Recommendation Report for Planning Permission for Works or Extension to a Dwelling

REF NO: AW/249/20/HH

LOCATION: 5 Stanbrok Close
Aldwick
PO21 3SN

PROPOSAL: Garage conversion to annexe and side extension to rear of garage.

GROUND FLOOR PLAN

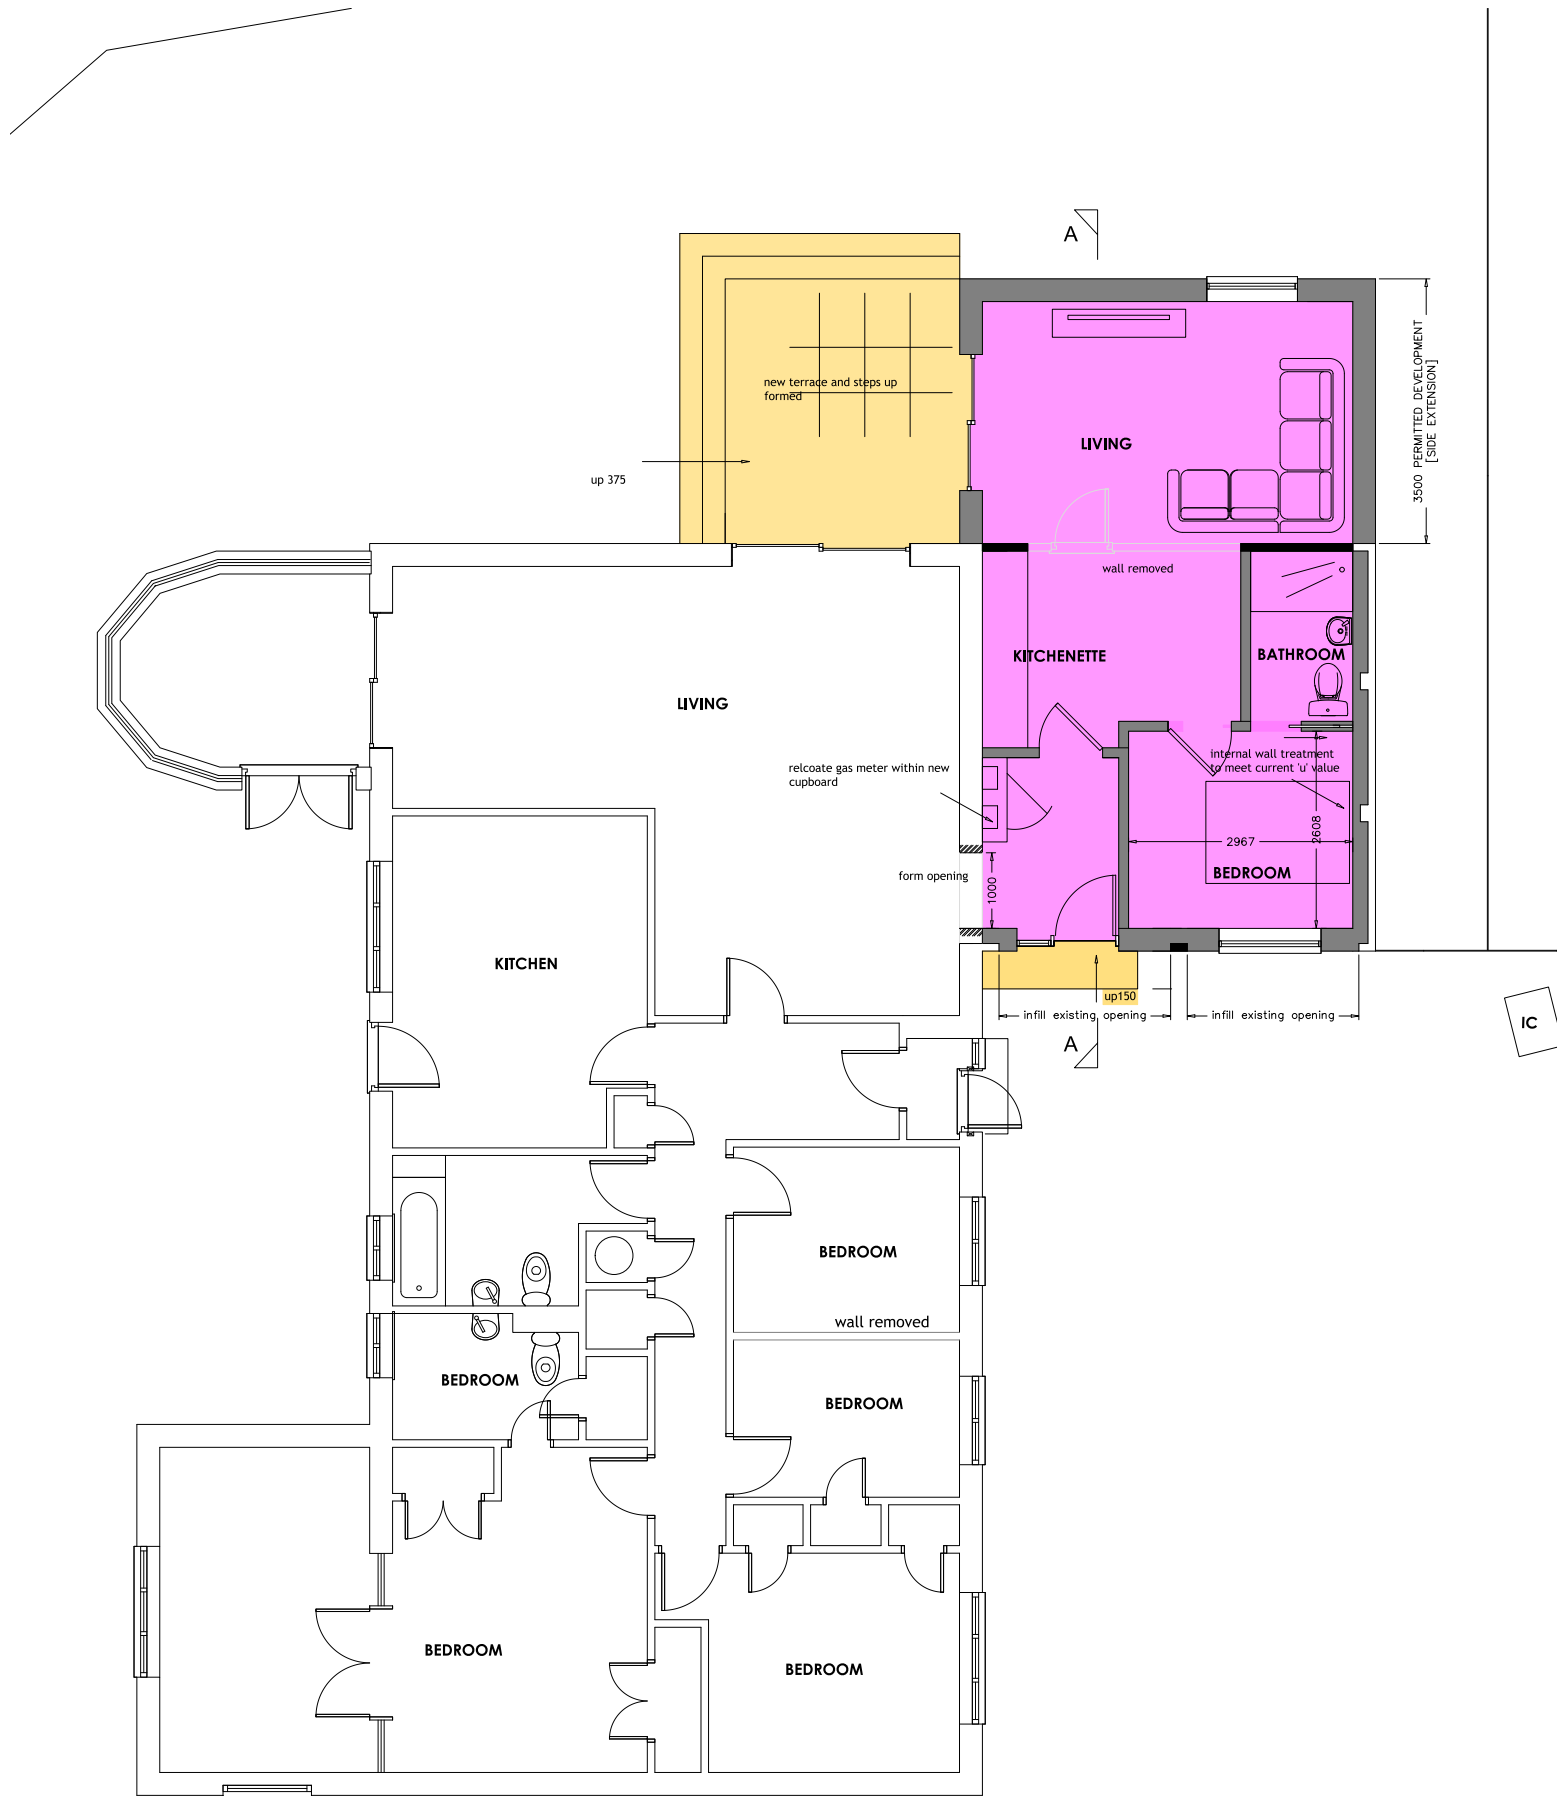
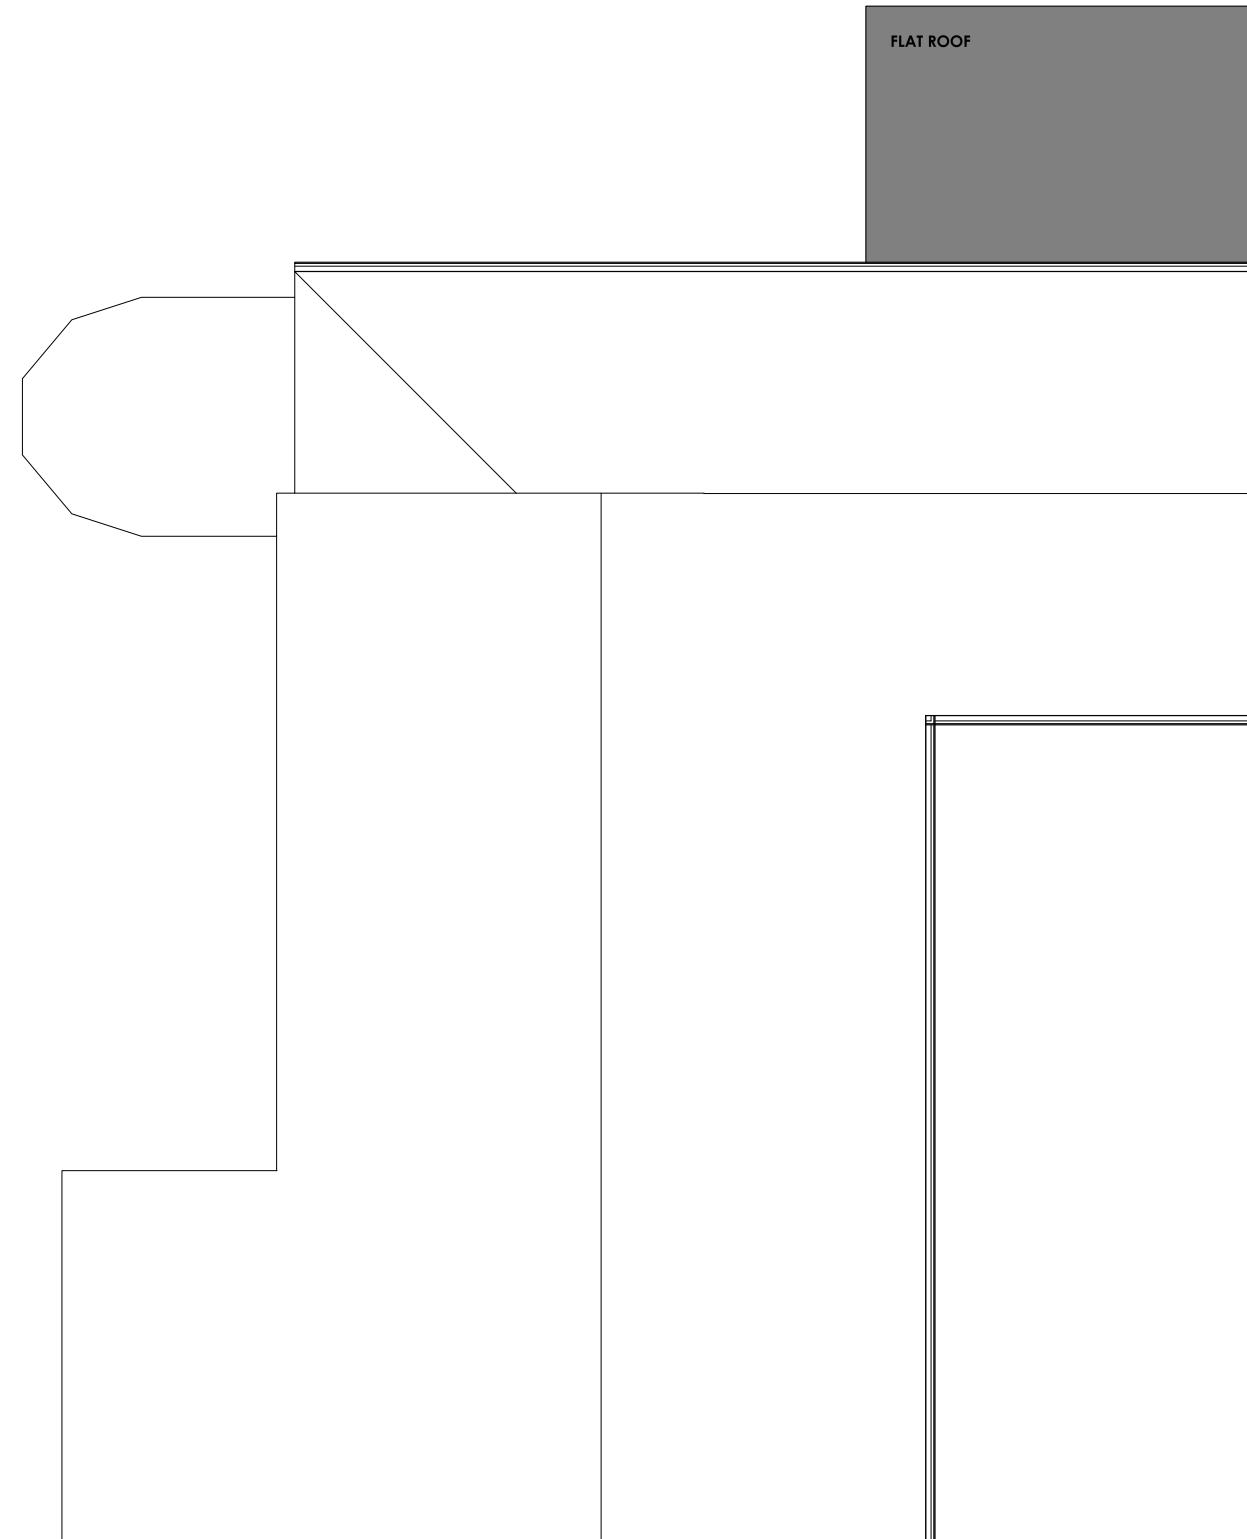
The proposed extension will sit behind the existing double garage, springing from the northern elevation by 3.5m. Additionally, it is proposed to be the full width of the garage at approximately 5.4m.

NORTHERN ELEVATION

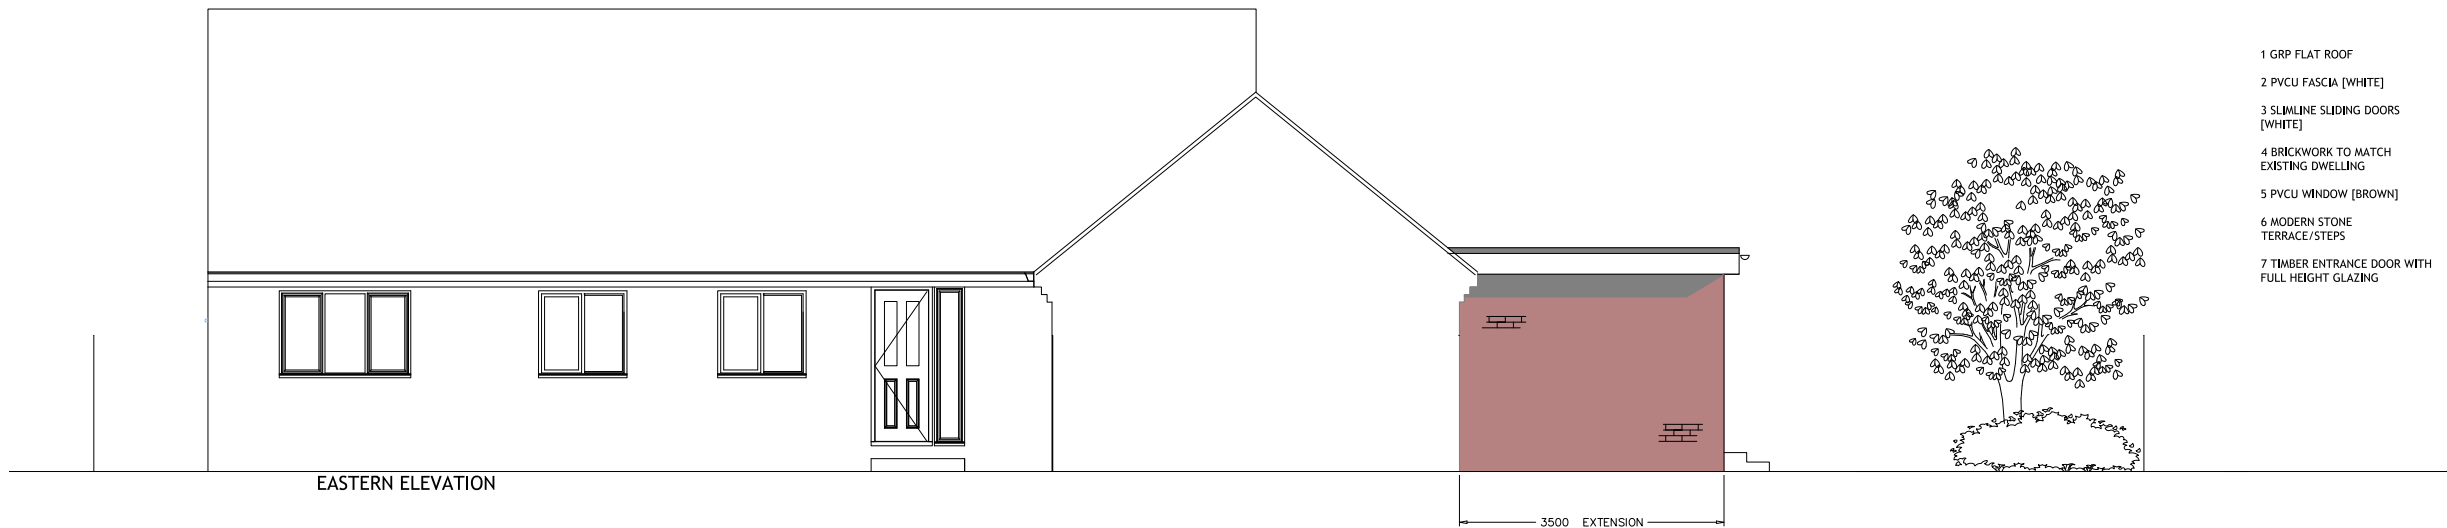
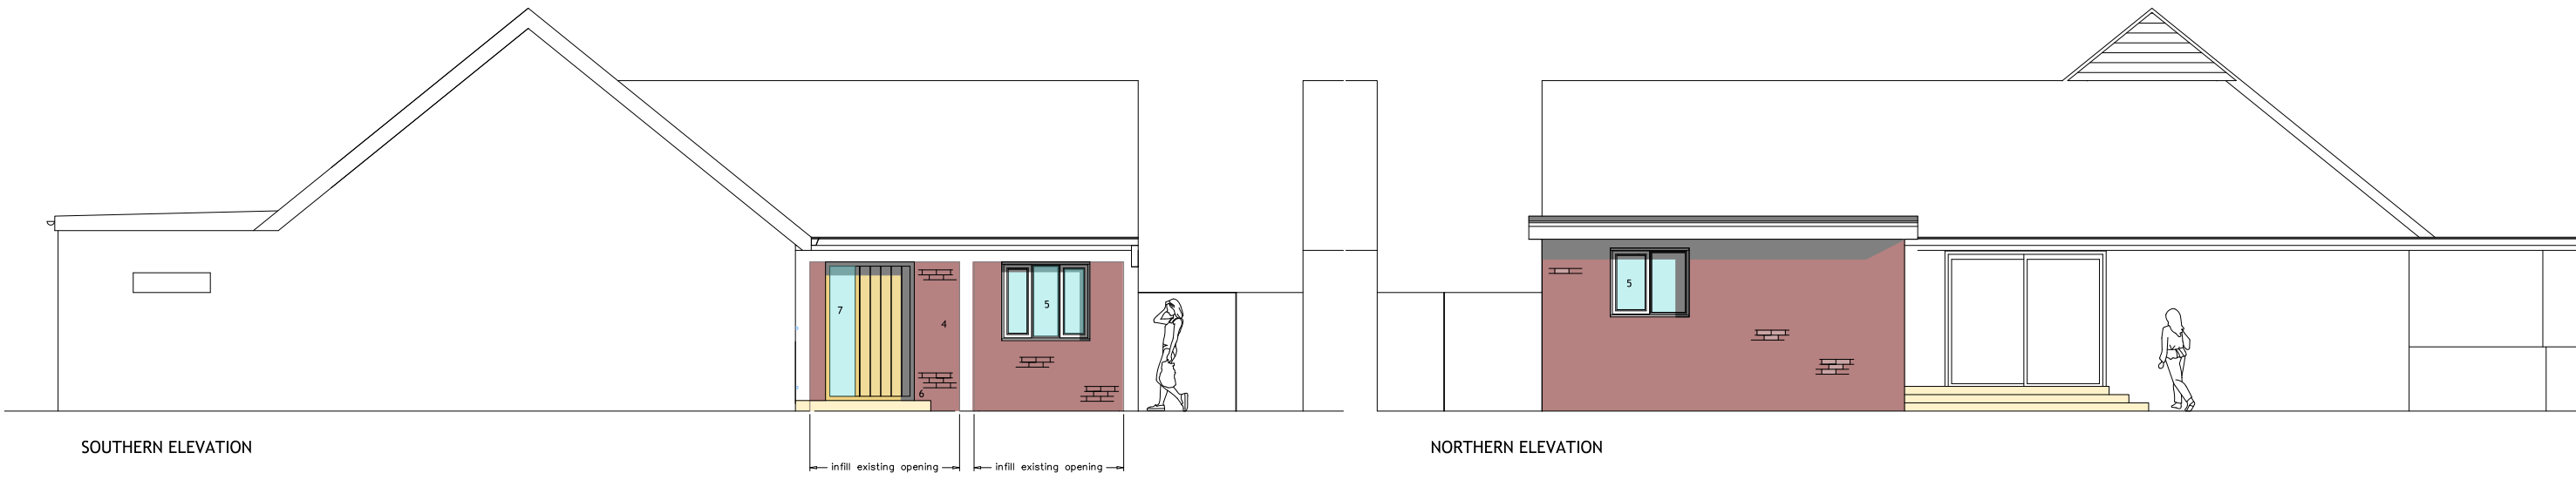
The eaves to the proposed extension are to be approximately 100mm higher than the eaves to the existing roof, it is felt that this is not a significant difference, therefore the proposed extension is still felt to be subservient to the host dwelling.

The 1.4m gap between No 5 and its closest neighbour to the East will be maintained, no windows are proposed to the Eastern Elevation therefore no issues regarding overlooking are expected. No further views, other than those that are already visible are expected to occur, with all proposed fenestration located on the Northern, Western and Southern Elevations.
